Title: Figure 3.1.5 Field Numbering Plan
Green Hill G

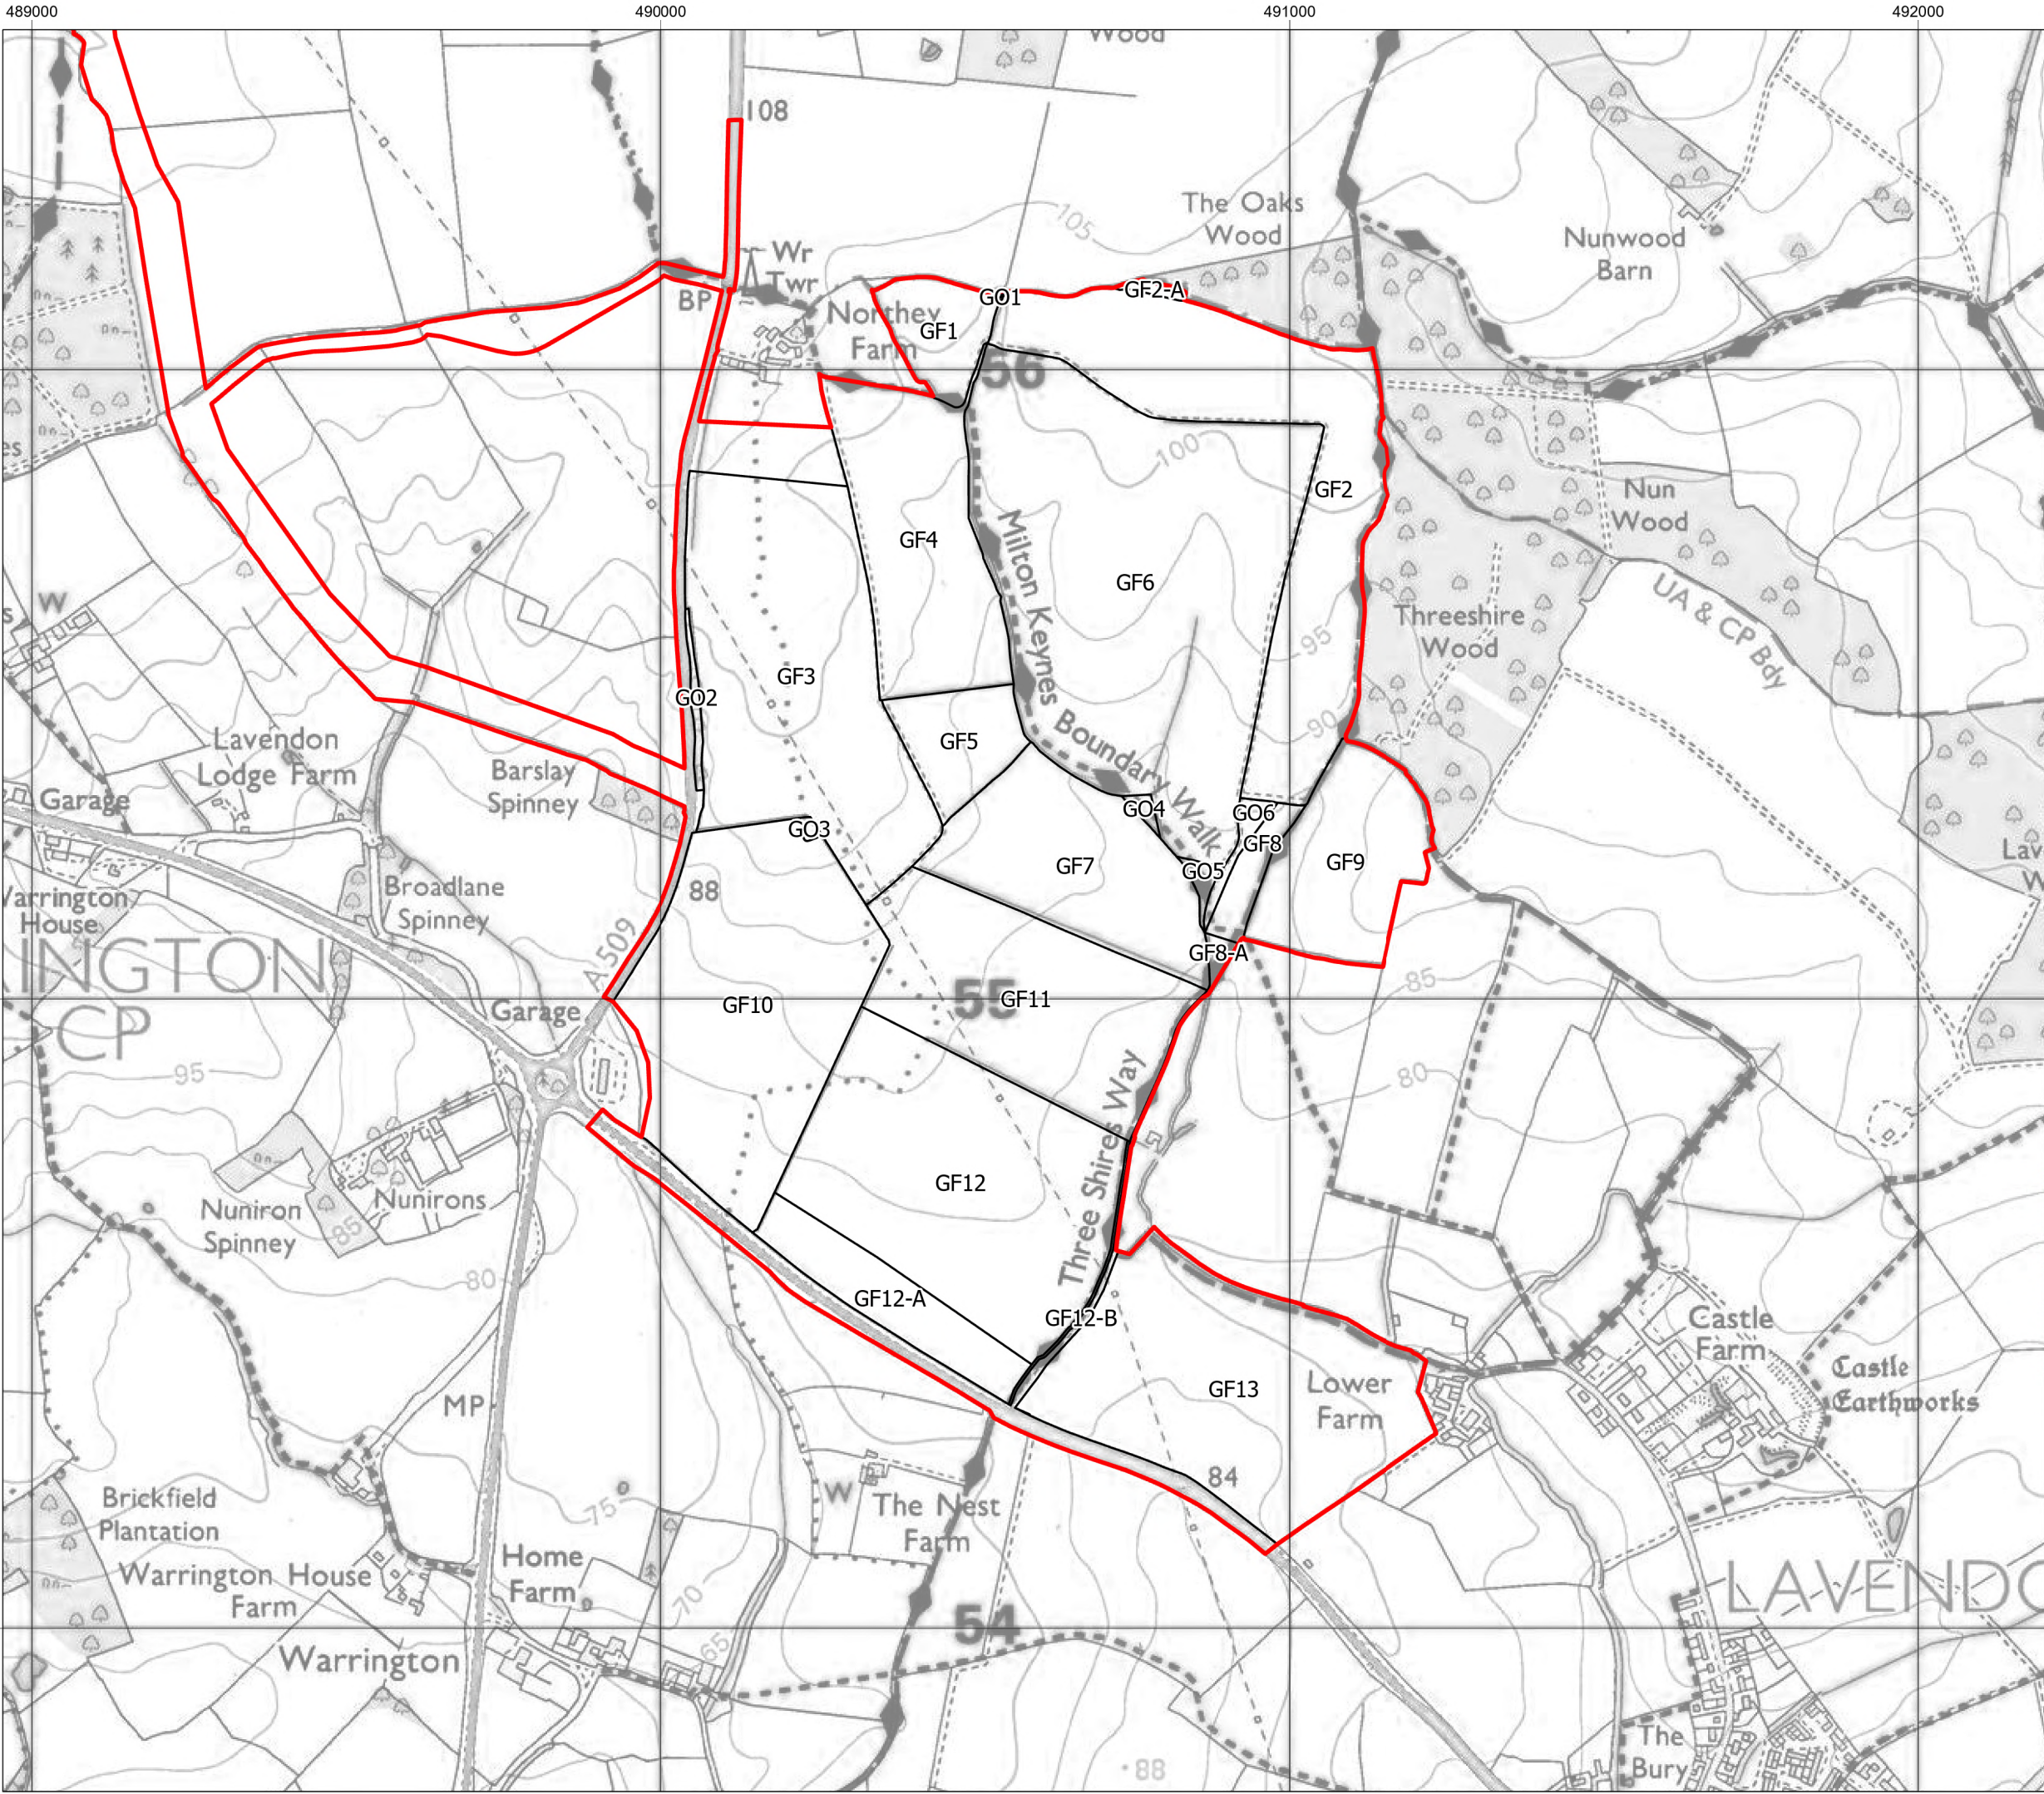
Site G

GF1 Reduce panels in the South side of the field

GF3 Reduce panels in the north of the field on the farm boundary

DF4 and reduce panels on the north side and east side of the field along the PROW

GF5 and GF7 reduce panels along the east side of the field

GF6 Reduce panels along the west south and east of fields adjacent to the PROW

GF9 reduce panels on the east and north sides running along the PROW

GF13 Reduce panels on the east side advance to the buildings by note 5 on plan.
